CITY OF ALBUQUERQUE

**Re: Desert Hills Kingdom Hall Grading and Drainage Plan
Engineer's Stamp dated 9-15-06 (D18/D29)**

Based upon the information provided in your submittal dated 9-14-06, the above referenced plan is approved for Building Permit. Please attach a copy of this approved plan to the construction sets prior to sign-off by Hydrology.

GRADING AND DRAINAGE PLAN

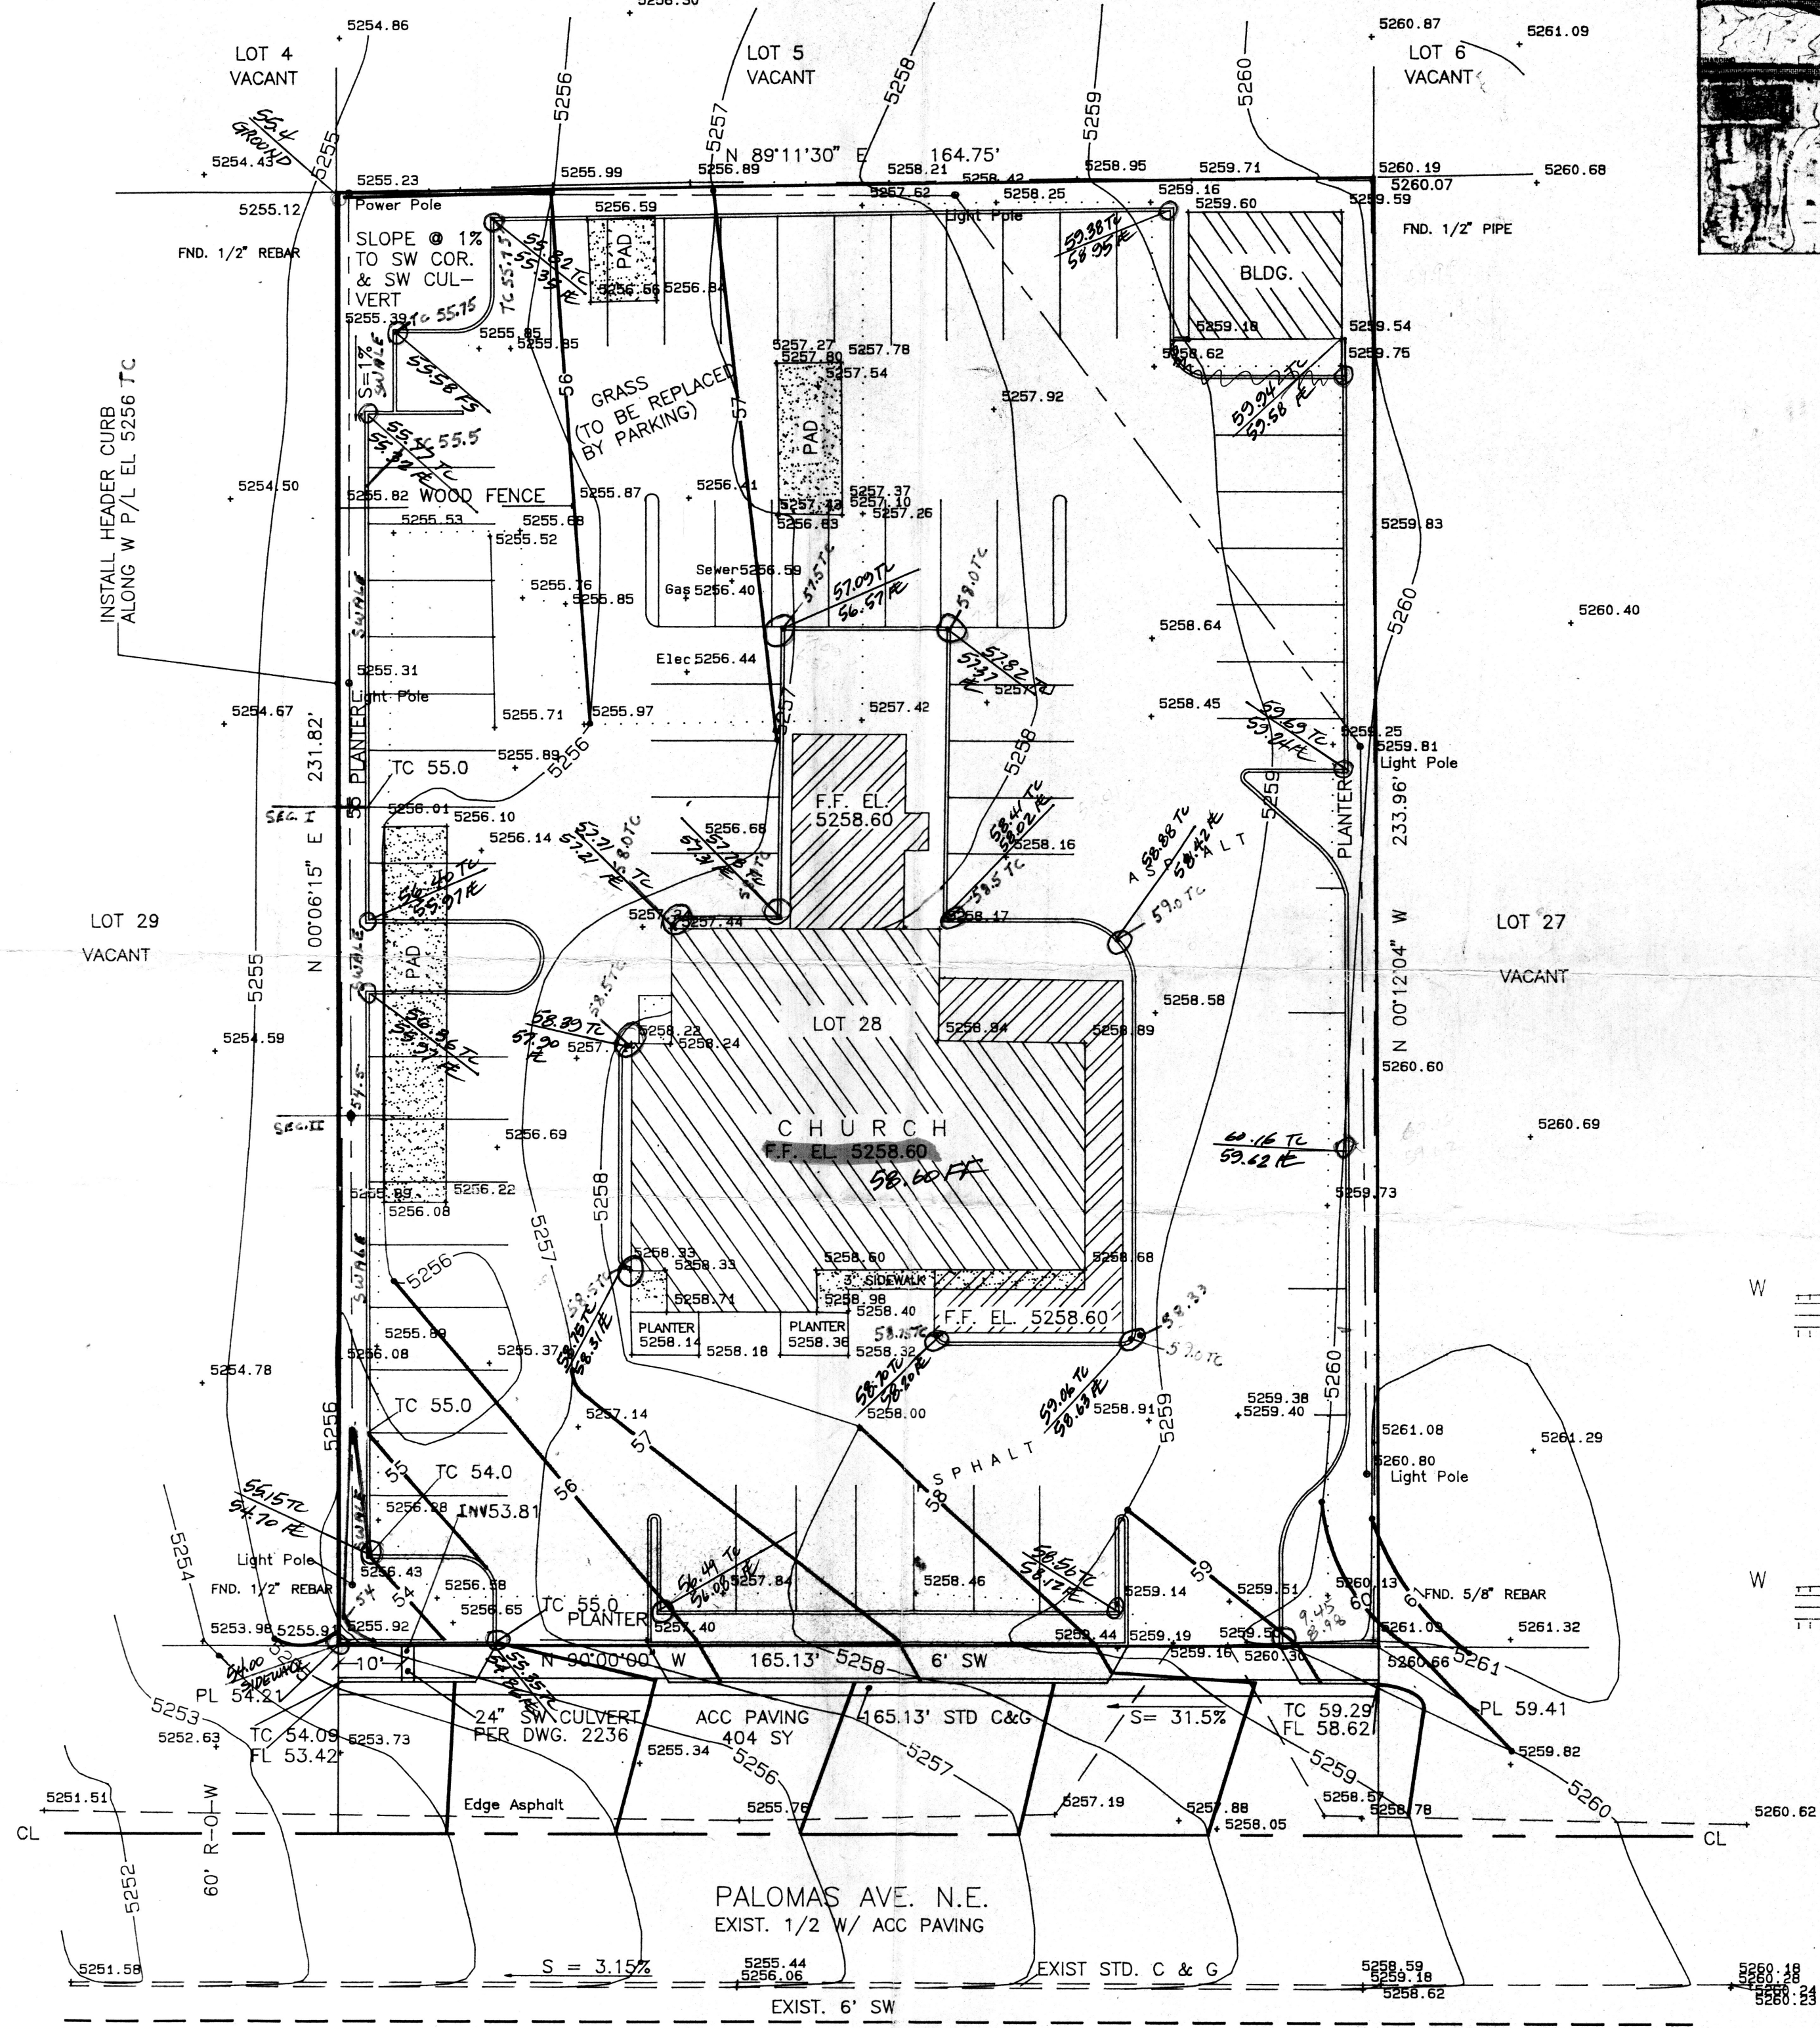
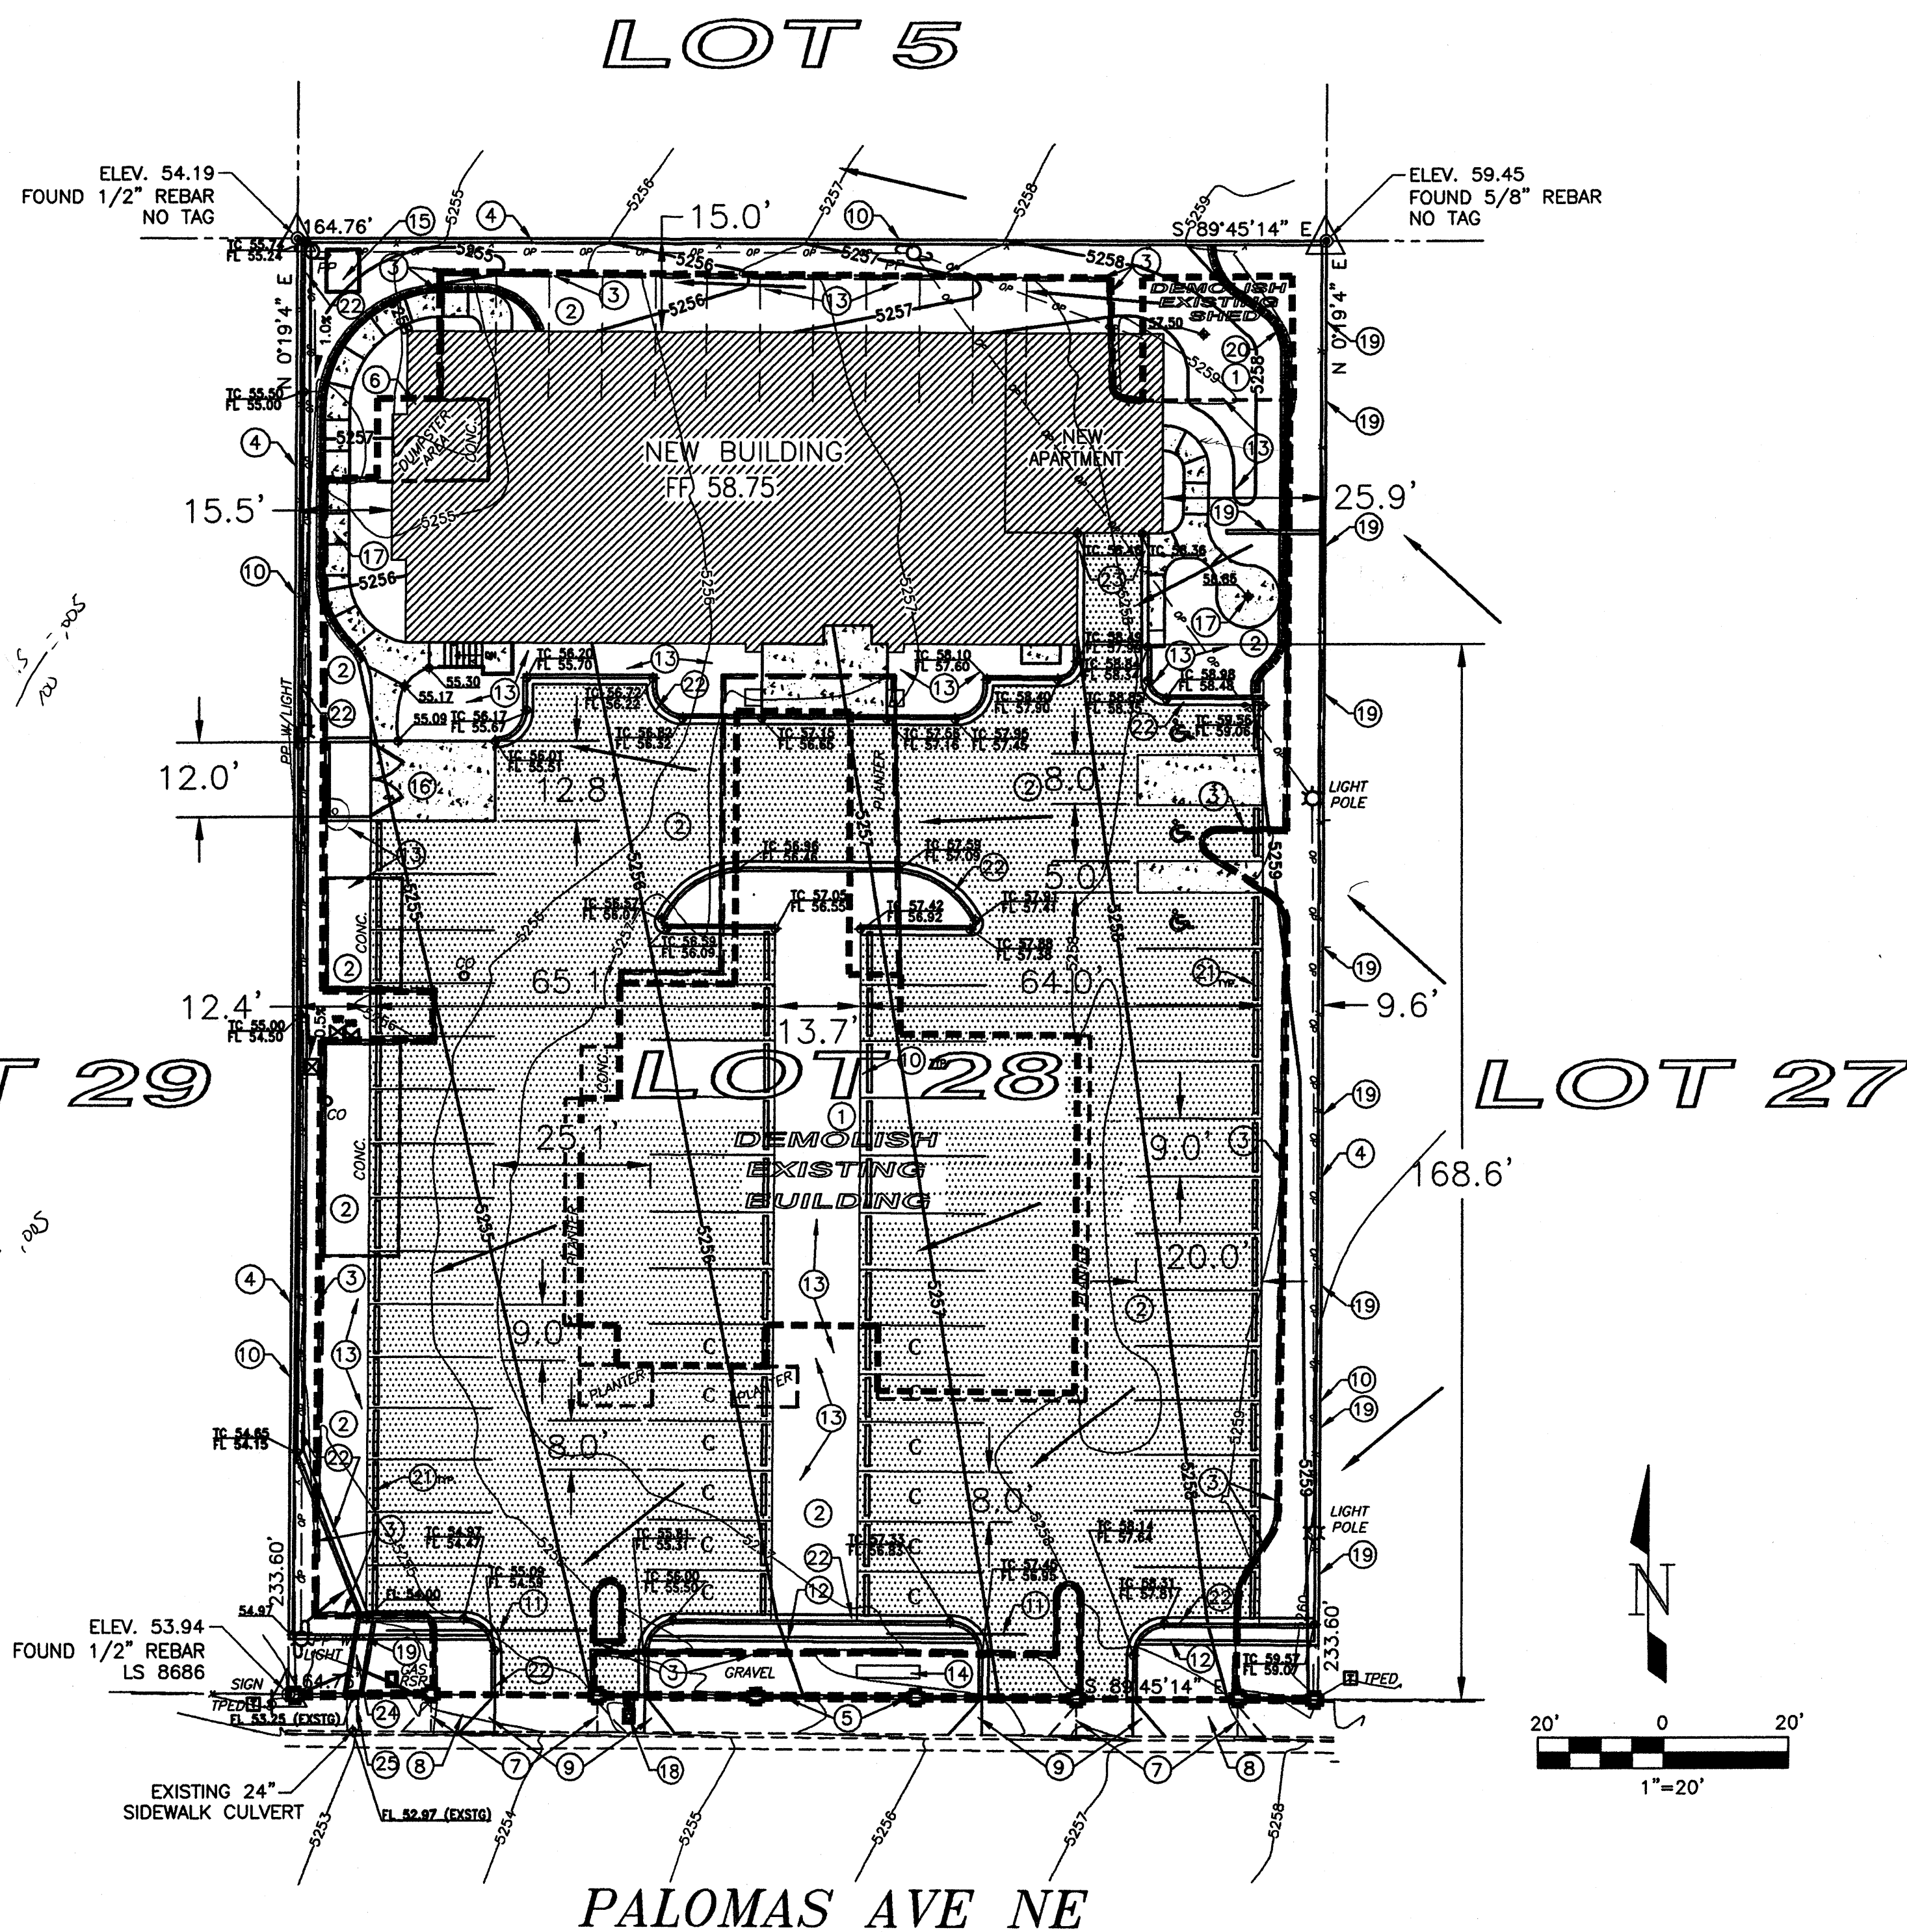
- Add a drain to the trash enclosure. Drainage from trash enclosures is required to be conveyed to the sanitary sewer. This is a relatively new requirement of the DPM.
- Engineer Certification per the DPM checklist will be required.

TITLE MASTER DRAINAGE & GRADING PLAN

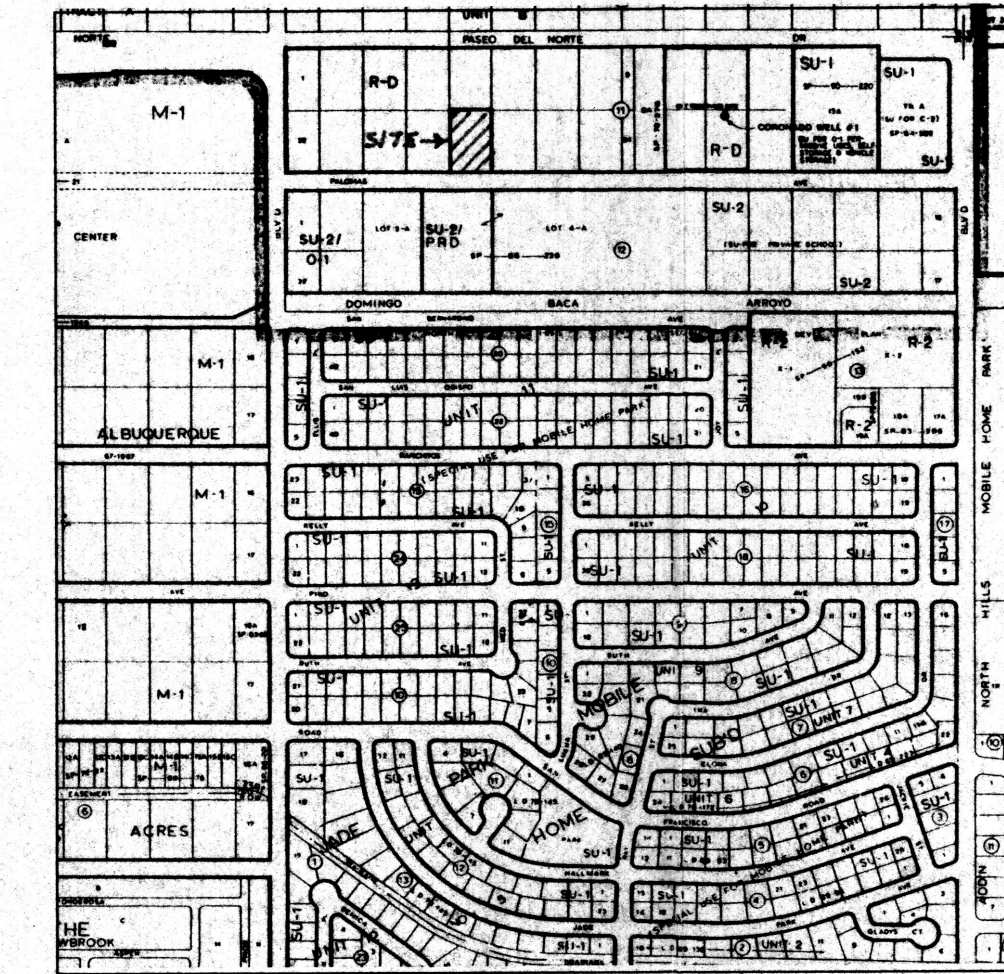
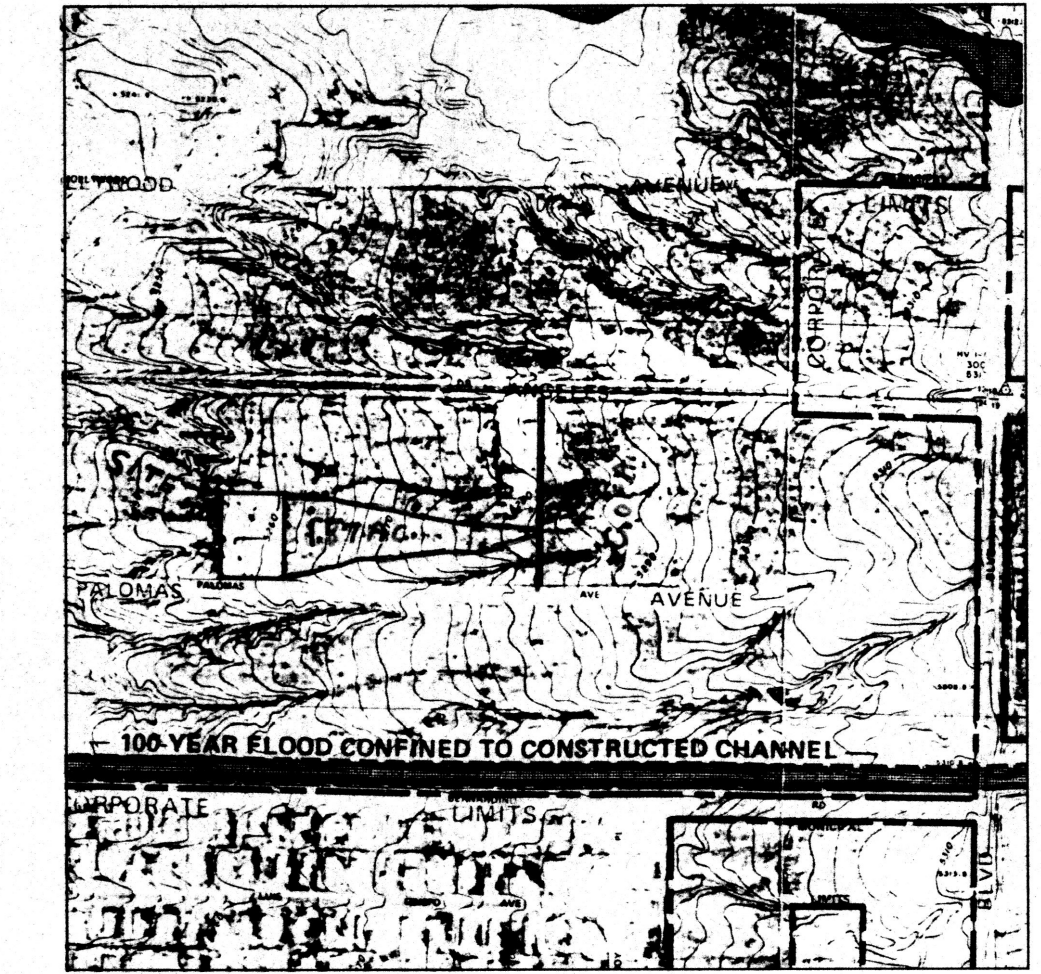
The Engineer's Certification does not comply with the DPM checklist.

1. Indicate the as-built elevations on the Plan. Typically this is done by putting a line through the proposed elevation and writing the as-built elevation next to the proposed. If the as-built elevation matches the proposed exactly a checkmark may be placed by the proposed instead.
2. The Certification Statement is worded incorrectly. It should be "substantial compliance" instead of "essential compliance".
